**RE: RESPONSE TO ADDITIONAL QUERIES SSD-76555711 – 3-5 HELP STREET, CHATSWOOD**

This letter has been prepared by Mecone on behalf of Loftex Chatswood Pty Ltd (the applicant) in relation to the State Significant Development Application (SSDA) SSD-76555711 for 3-5 Help Street, Chatswood (the site).

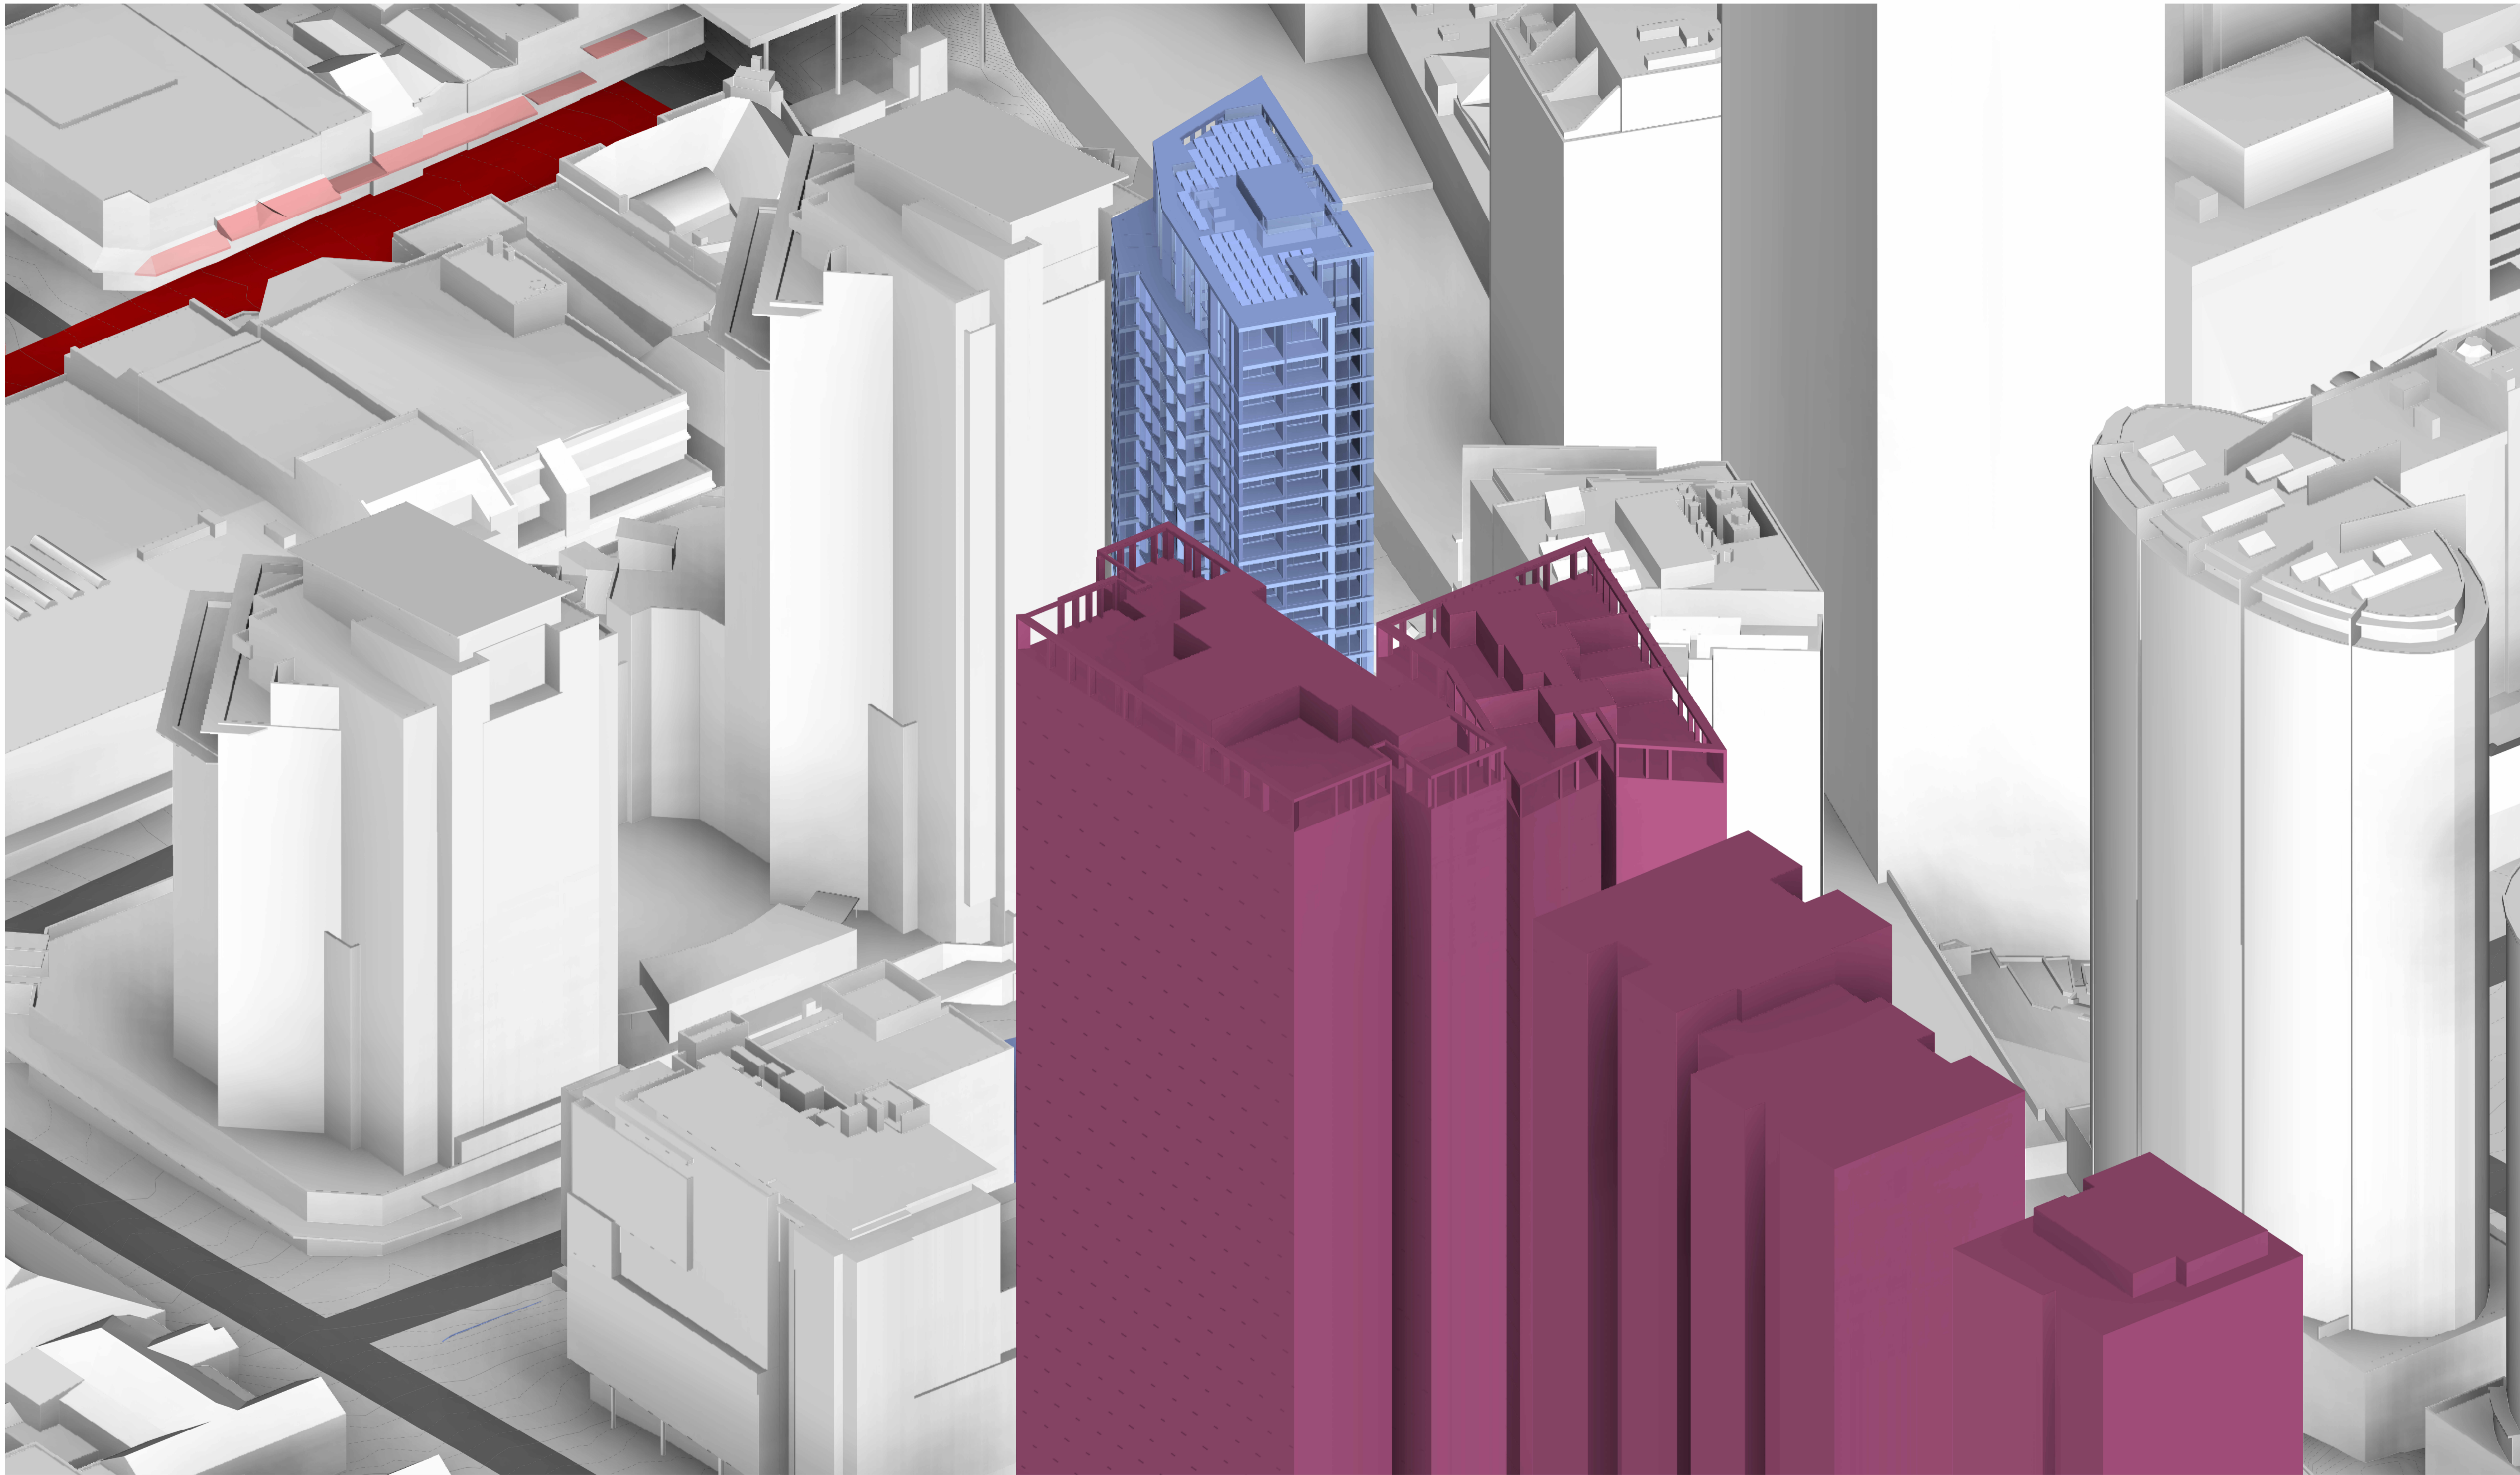
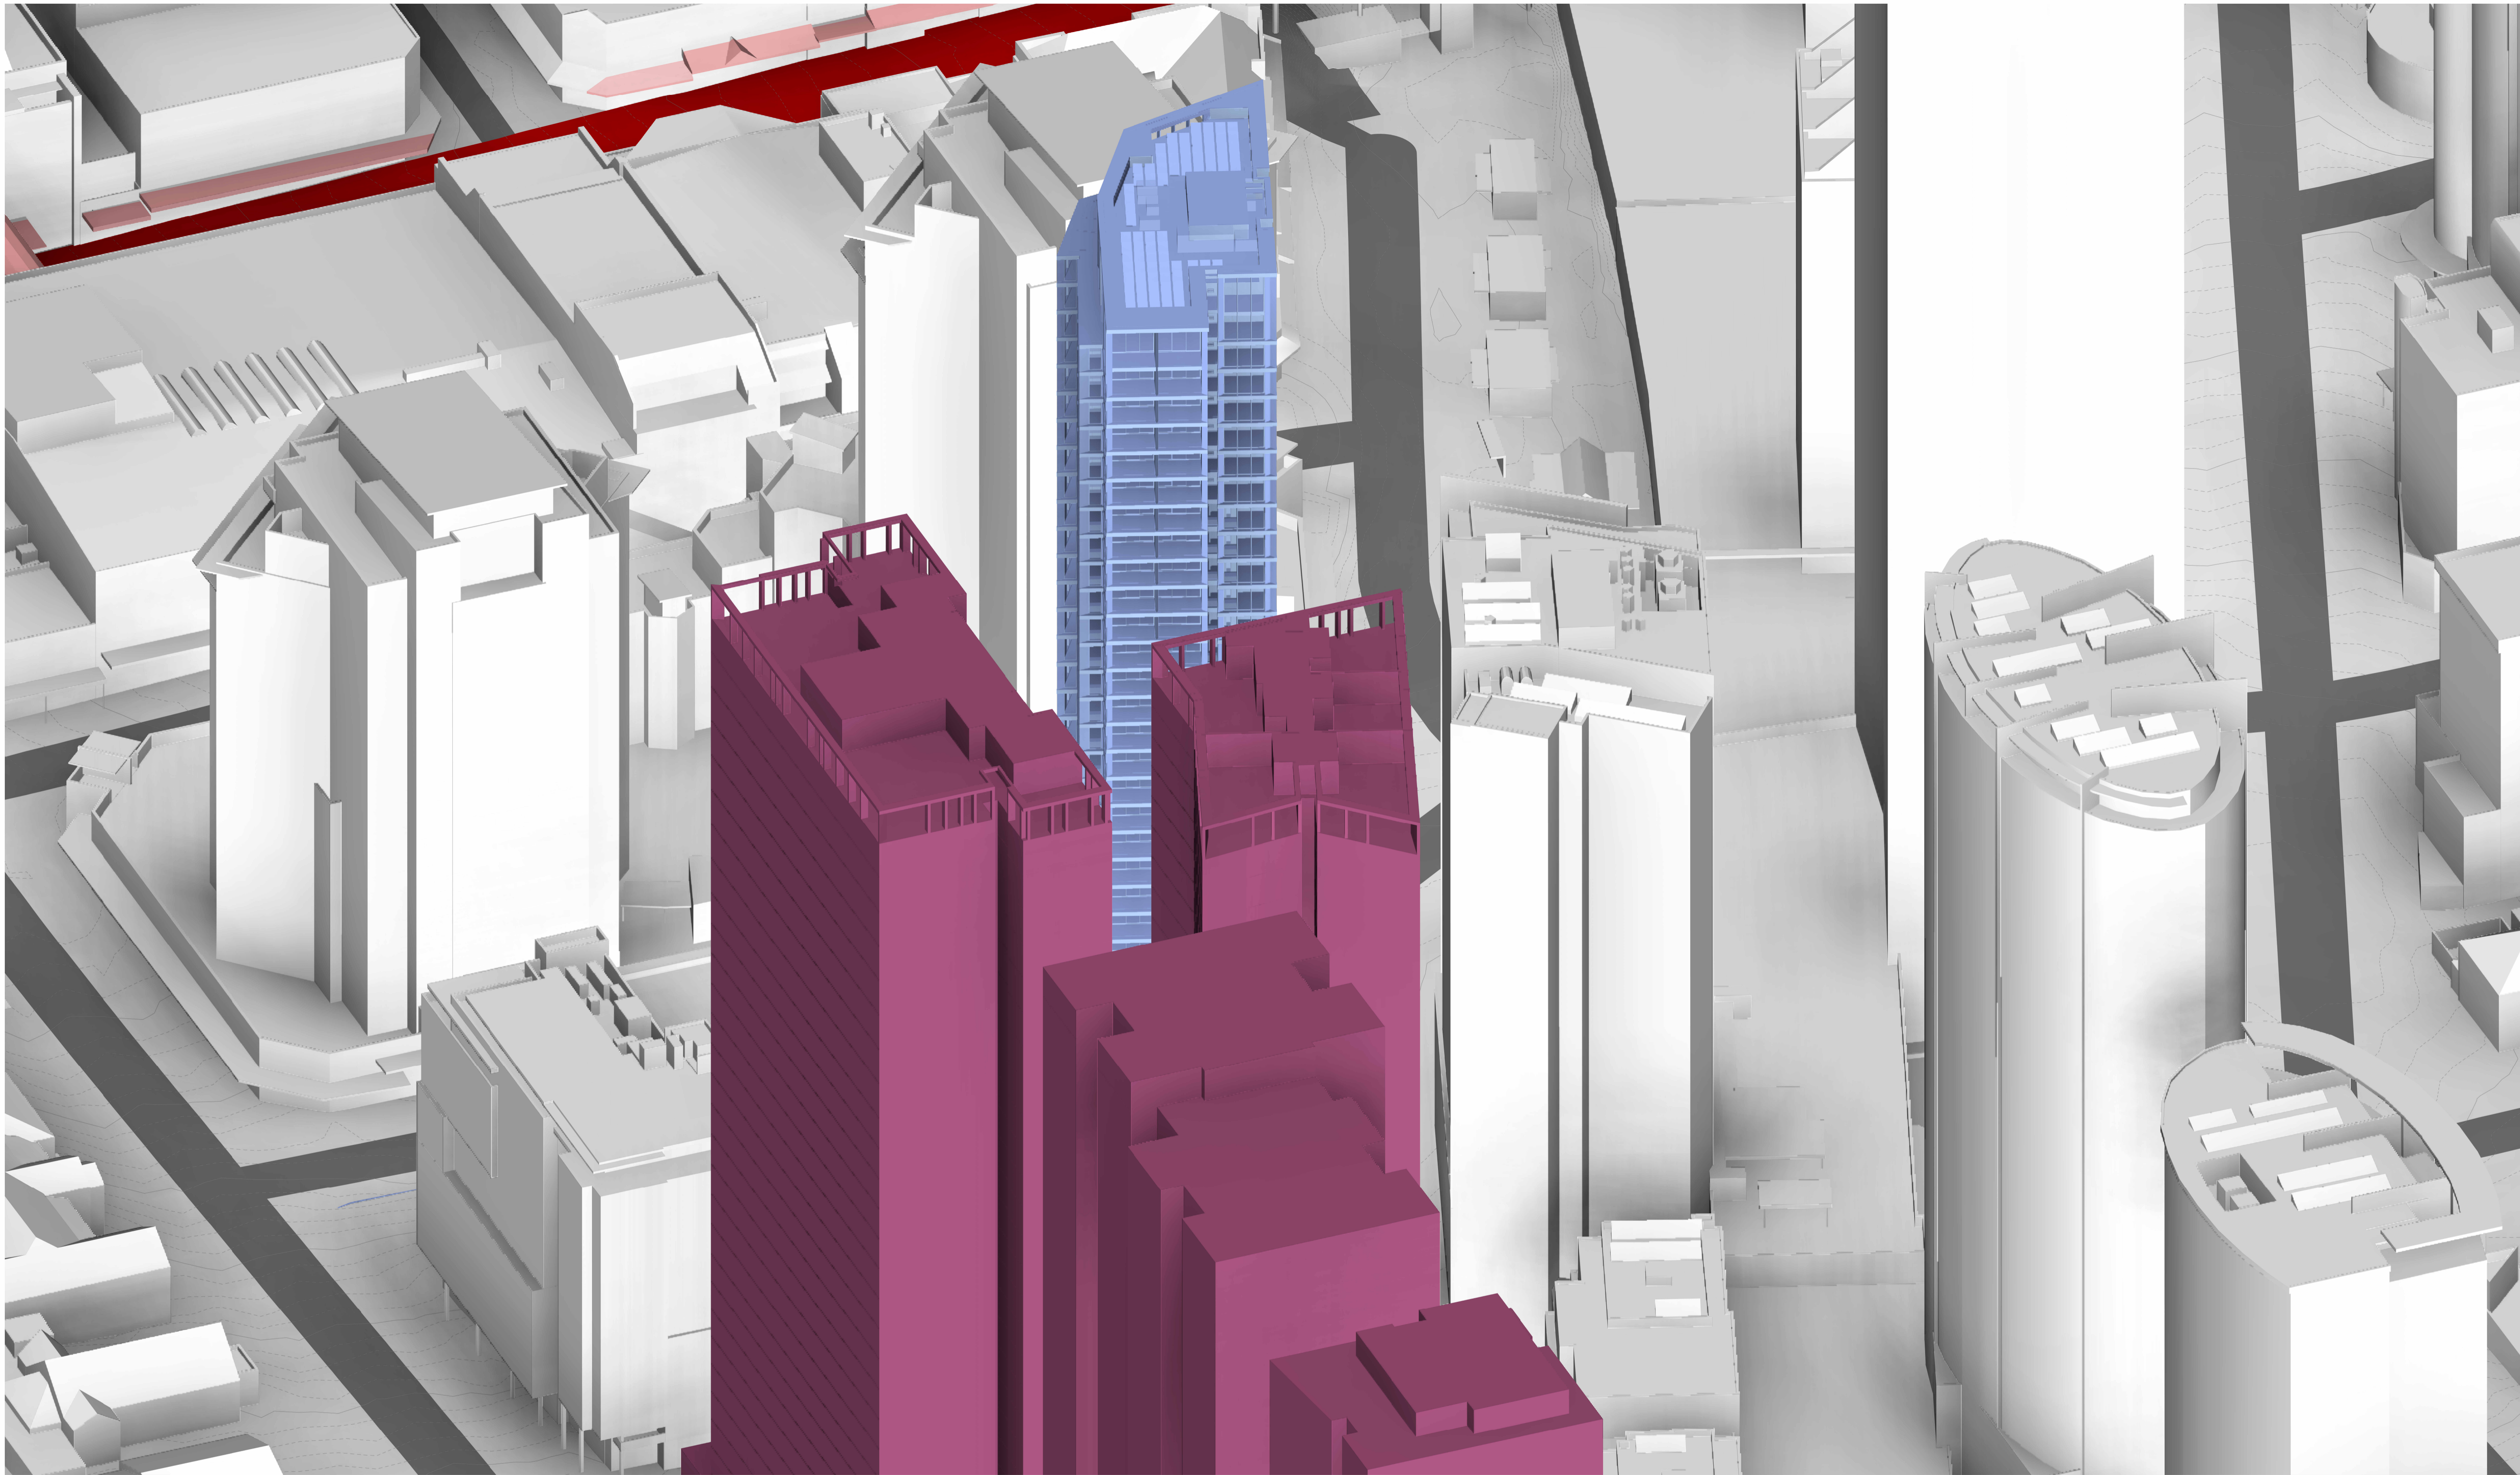
Comment/Query	Response
<b>Solar Access</b>	
<p><b>The following was requested via email from DPHI on 13 October 2025:</b></p> <p><i>The application would benefit from additional solar access data detailing 5–10 minute intervals of sunlight exposure for apartments receiving less than two hours of direct sunlight. This information would strengthen my assessment report by allowing a more thorough discussion of the limitations posed by the proposed northern buildings and demonstrating that the design has maximised solar access to the greatest extent possible.</i></p> <p><b>The following was requested via email from DPHI on 14 October 2025:</b></p> <p><i>Following on from my additional information request yesterday, could you please also supply solar access data from 8am-9am and 3pm-4pm to help justify the site not meeting the ADG sunlight requirements?</i></p>	<p>As requested, the updated View from the Sun Diagrams have been provided at <b>Attachment 1</b> and <b>Attachment 2</b>, showing the solar access to the building façade in 15-minute increments from 8am to 4pm.</p> <p>A detailed statement addressing solar impact has been provided by EMBECE at <b>Attachment 3</b>. In summary, if the proposed SSDA to the north of the site is approved in its current form, with the consideration of extended solar access hours to include 8am-9am and 3pm-4pm, then at least 119 of 166 apartments (74%) will receive 2 hours of sunlight to either the habitable rooms or private open space between the hours of 8am to 4pm on June 21,.</p> <p>Noting that 74% of apartments will still have access to sunlight in mid-winter, despite the proposed SSDA to the north, is evidence that the proposal can satisfy the objectives of Part 4A-1 of the ADG.</p> <p>A detailed summary of how the design achieves compliance with the objectives of Part 4A-1 of the ADG is provided in <b>Attachment 3</b>.</p>
